**Consultation Response from KC Conservation and Design**
**2019/91957 5, Two Gates, Holme Lane, Slaithwaite, Huddersfield, HD7 5UG**
**Erection of extensions and alterations and formation of new access**
**Date Responded: 08/08/19 | Responding Officer: Craig McHugh | Responding Ref: CV 5/169**
**Summary**

**Drawing:**  
Scheme As Proposed - Planning

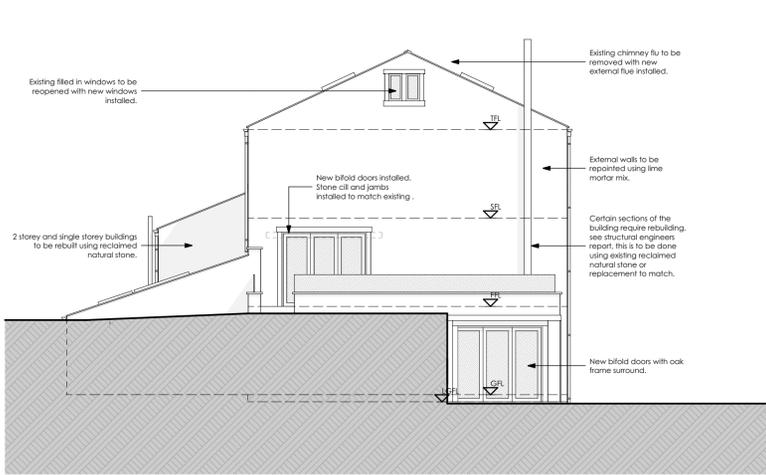
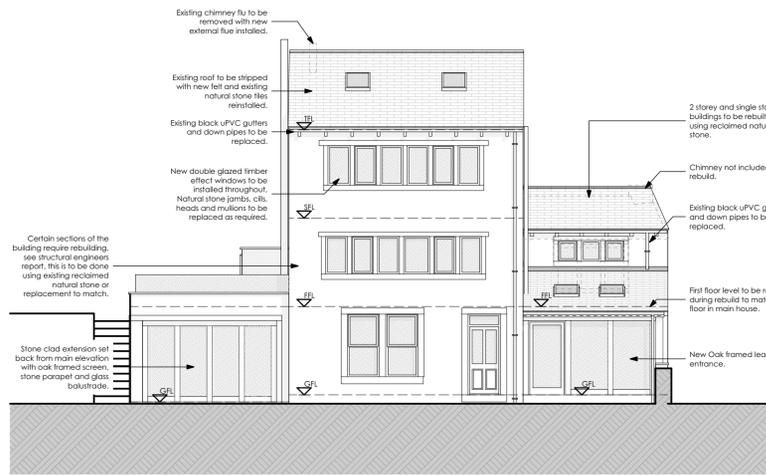
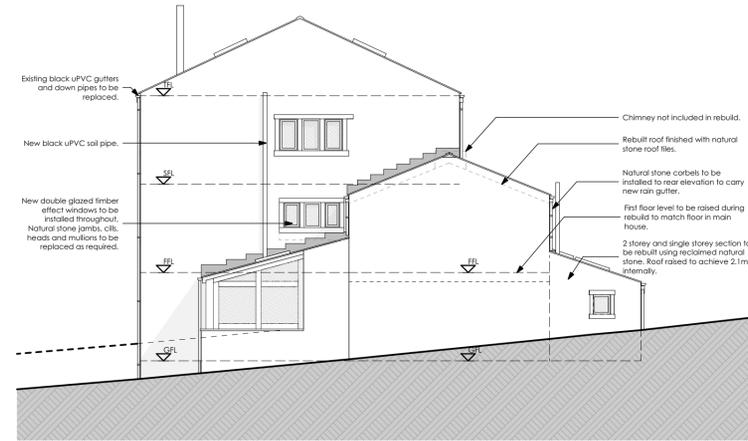
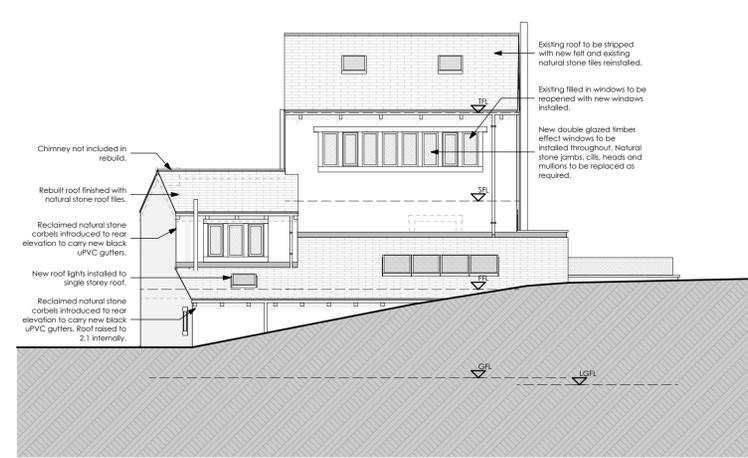
The single storey lean-to extension nearest the listed building would introduce materials and details not in keeping with the existing building or the local townscape and have a harmful impact on the setting of the listed building and the townscape, particularly the use of large expanses of glass.

The addition of two further extensions would lead to the building having a very complex form comprising three, two and single storey elements, pitched, lean-to and flat roofs. The impact of the extensions would be compounded by the use of materials not in keeping with the existing building to create an unsatisfactory composition.

We should seek revised designs more in keeping with the existing buildings through reducing the scope of the material palette and using details more in keeping. Of particular concern in this context is the use of oak framing and large glazing immediately adjacent to Holme Lane, where the contrasting materials and details have greatest impact on the townscape and setting of the listed building.

We should seek revised designs with a simpler form, though for example reducing the number of new extensions or using pitched or lean-to roofs to each extension.
